PLANNING APPLICATION REPORT

REF NO: **AW/178/10/**

LOCATION: 115 Aldwick Road
 Bognor Regis

PROPOSAL: Demolition of existing dwelling, erection of three storey building to contain 7 flats, 2x1 bedroom, 5x2 bedroom units with associated parking and bin store (re-submission of AW/242/09)

PLAN NO 639/1
SCALE 1:100
DATE 08/10

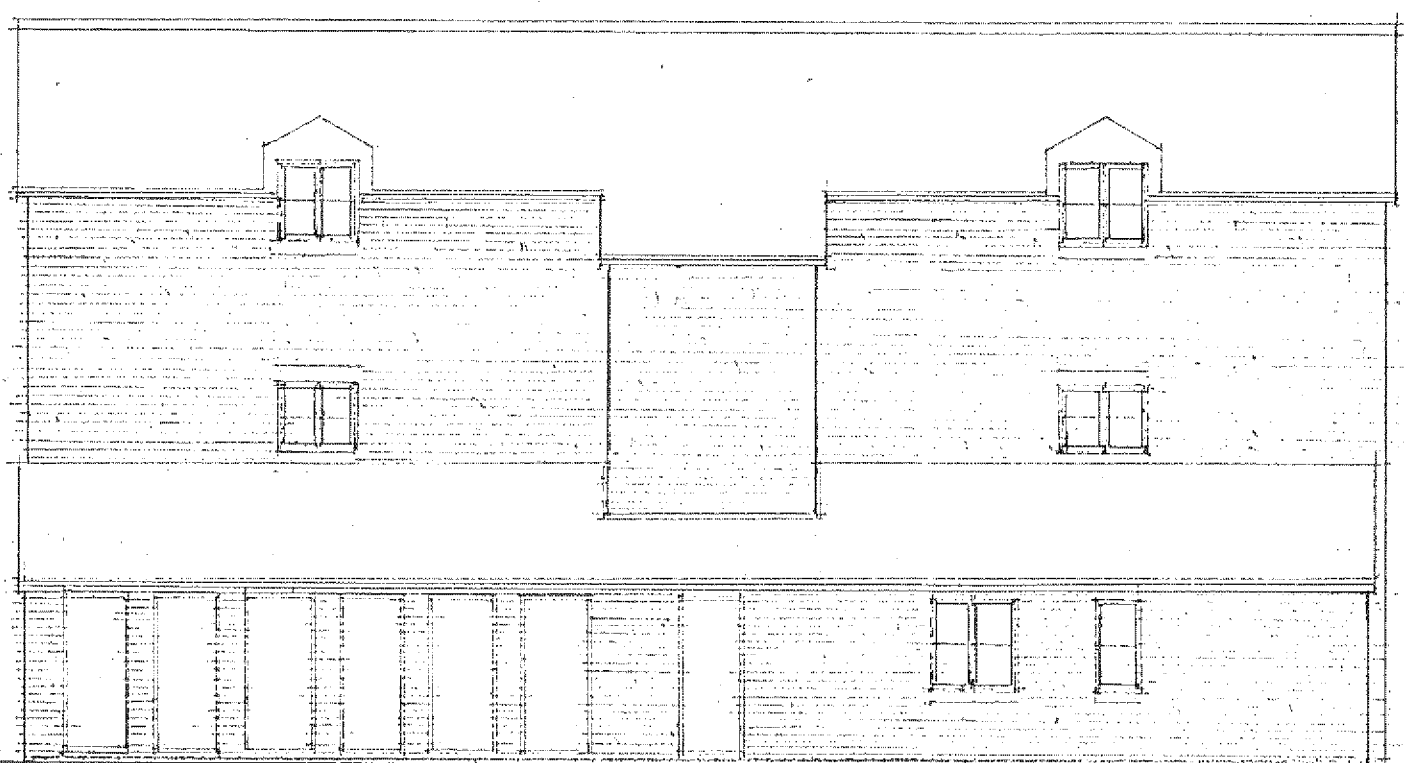
Additional windows are proposed on the north and south elevations over the previously approved scheme, however, given they will be sited in the side elevations of the proposed projecting gables fronting Aldwick Road and therefore will be orientated towards the public street scene along Aldwick Road and Princess Avenue, there will be no additional impact on neighbouring residential amenity from loss of privacy through overlooking from these windows.

The previously approved scheme provided ground and upper floor habitable room windows on the east facing elevation of the building that were not obscure glazed and therefore may have had potential for additional overlooking and loss of privacy for occupiers of residential properties to the east of the site including the adjacent property at 113 Aldwick Road.

This revised scheme still proposes ground and upper floor windows on the east elevation of the building with one additional ground floor window, however, additional planning conditions have now been recommended that will require the obscure glazing of these windows and therefore will reduce the overall potential for overlooking/loss of privacy to these properties. The net result of this is that the revised scheme will have less impact on neighbouring residential from overlooking/loss of privacy over the previously approved scheme under planning ref AW/242/09.

- 7 The approved first and second floor windows in the east facing rear elevation of the building shall be obscure glazed prior to the first occupation of the development and shall remain so thereafter.

PLAN NO 639/7
SCALES 1:200 1:500
DATE 08/10

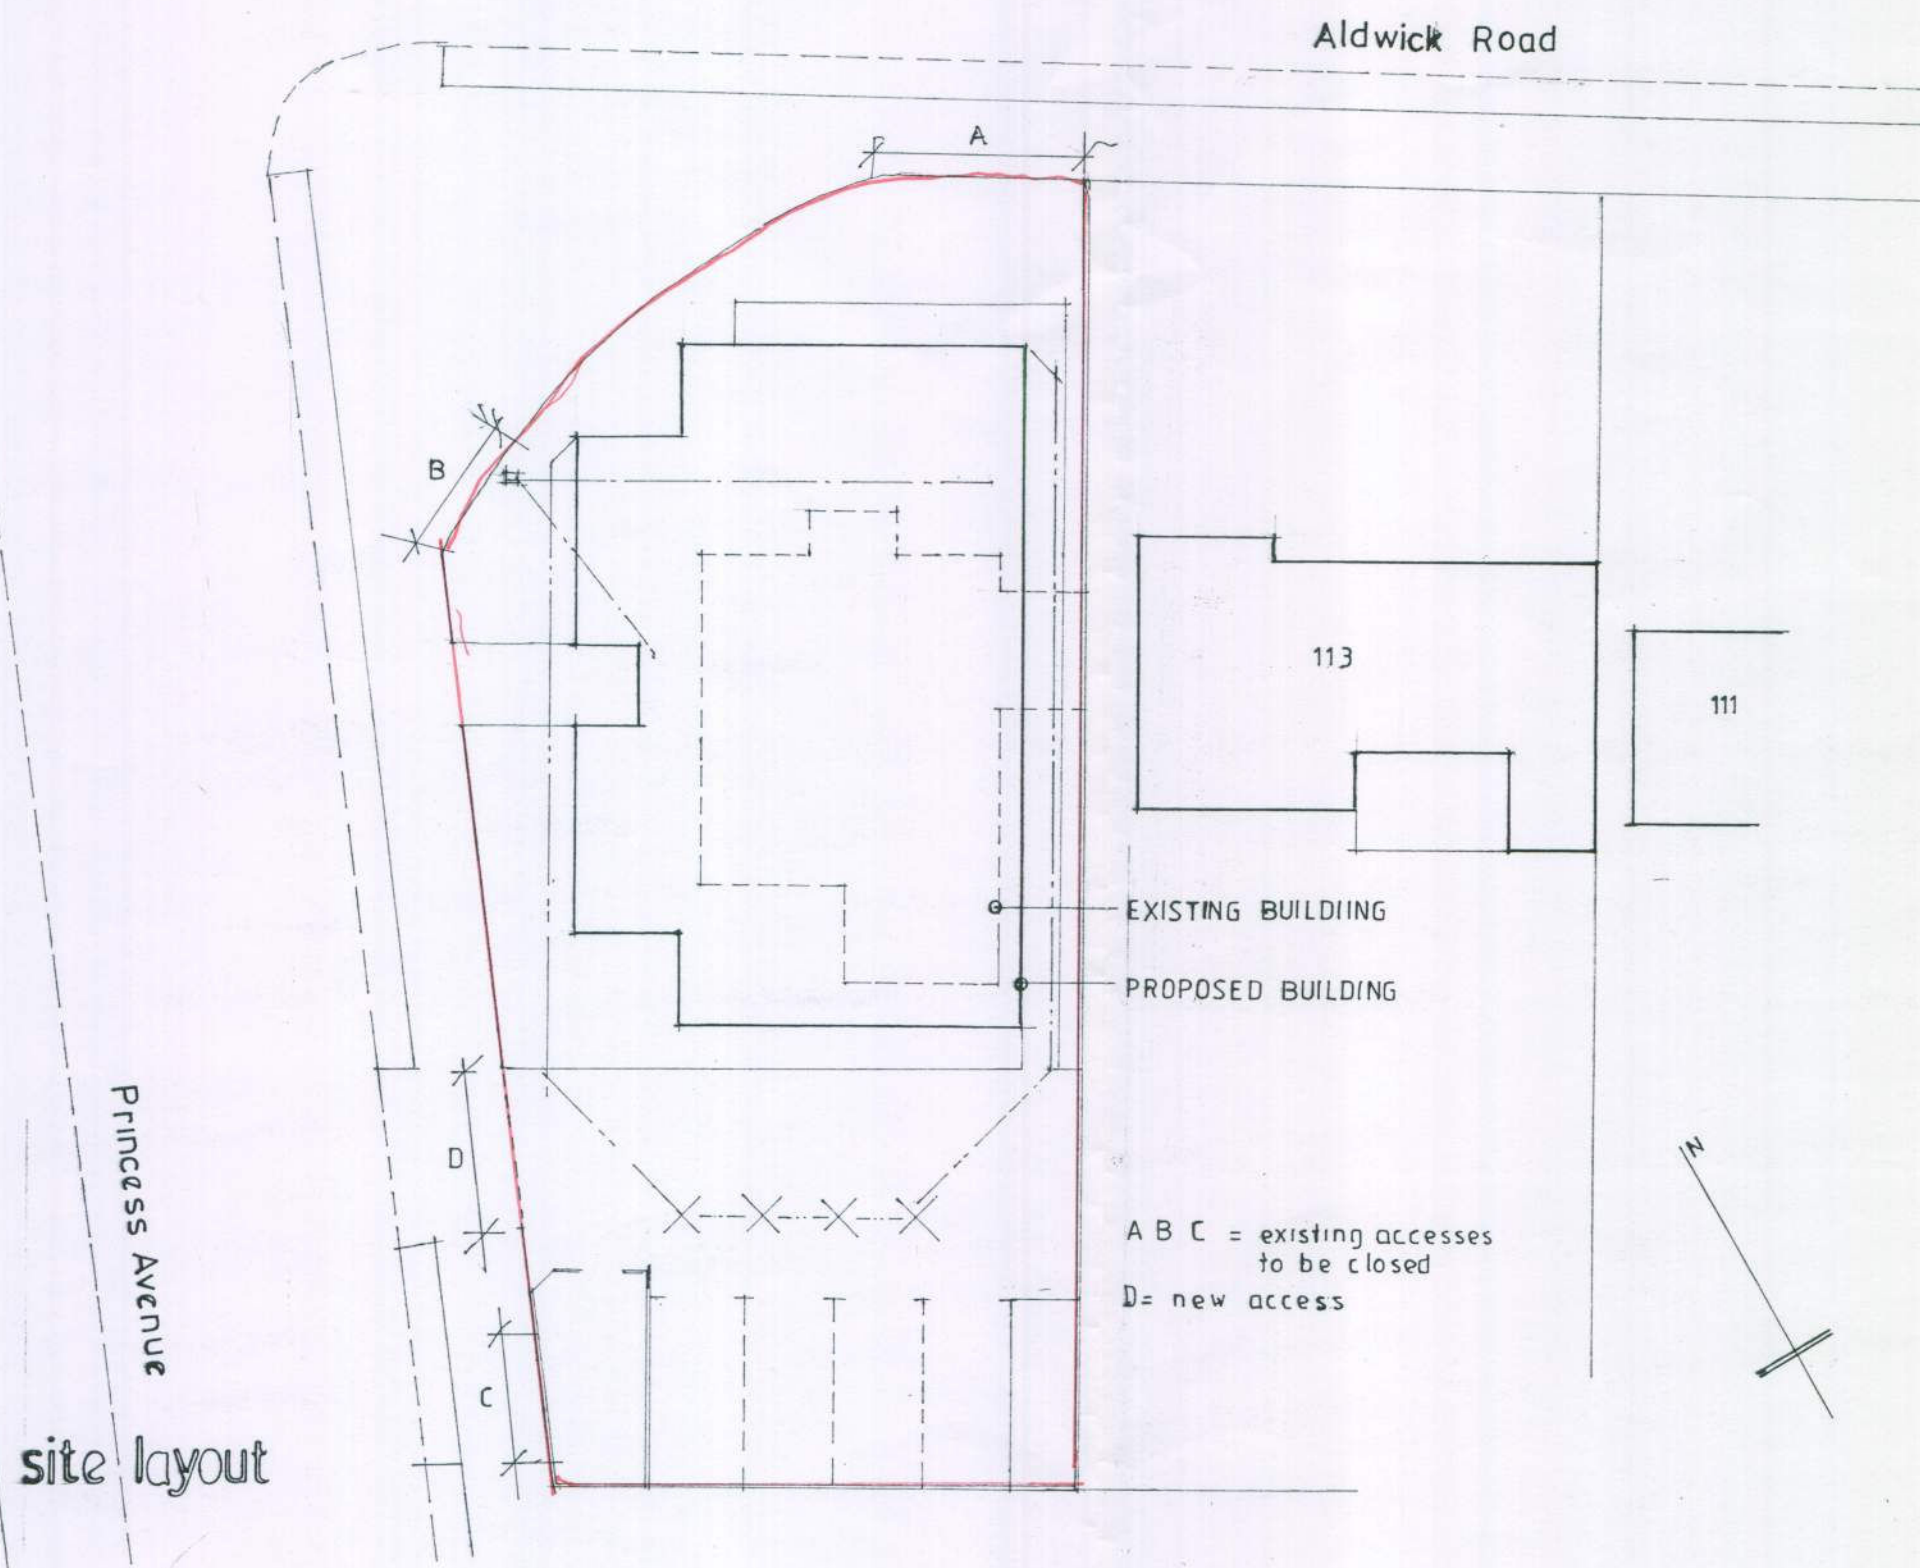
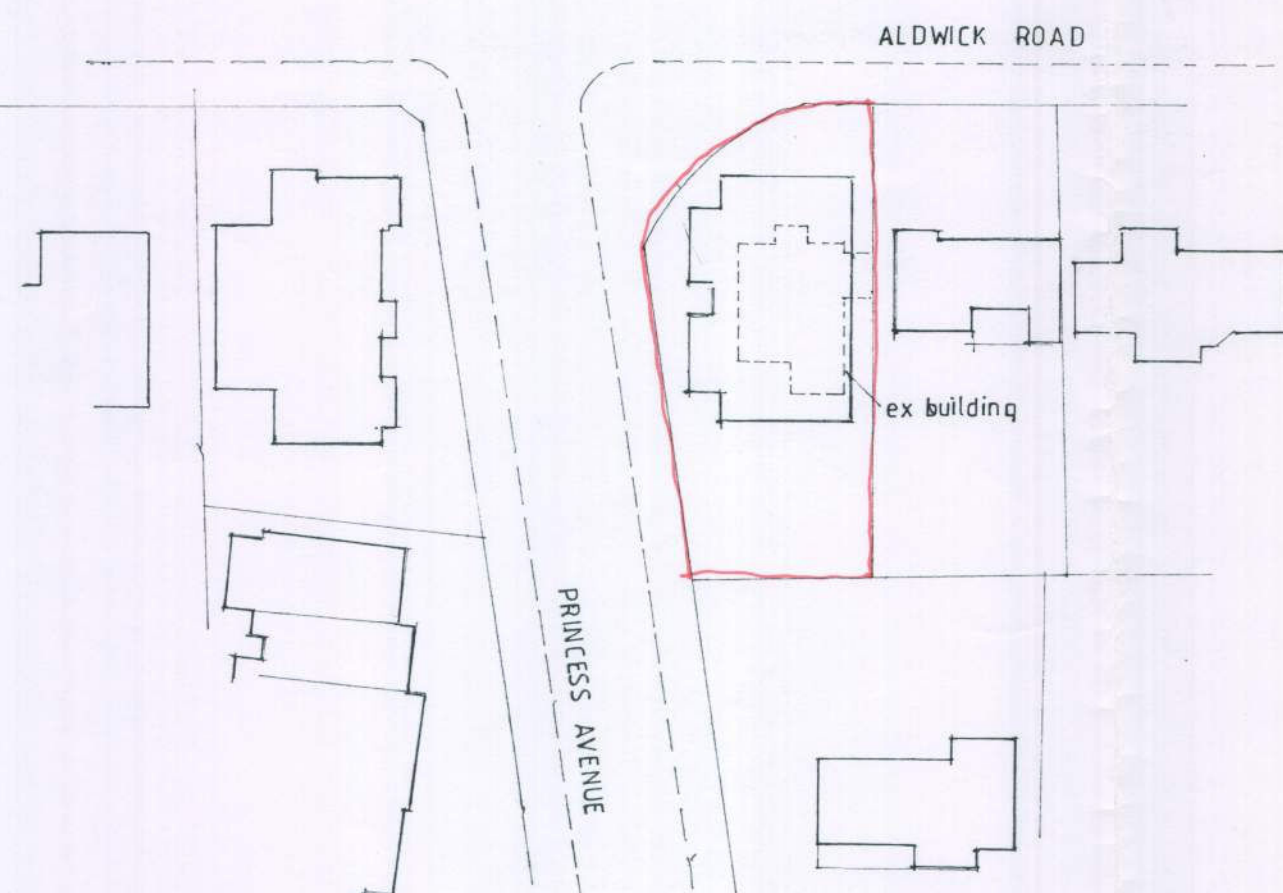
The parking and access arrangement is identical to that approved previously under AW/242/09. Two existing accesses on the front and rear of the site are to be closed off and a new access created in Princess Avenue. The scheme will include a total of four off road parking spaces. The County Highways Authority considers this access arrangement and parking provision to be satisfactory, in accordance with their maximum standards and have raised no objection to scheme. The proposed development is therefore considered acceptable in respect its impact on highway safety and traffic generation.

- 4 The building shall not be occupied until the parking spaces shown on the approved drawing no. 639/7 dated 08/10 have been provided and constructed. The areas of land so provided shall not thereafter be used for any purpose other than the parking of vehicles.
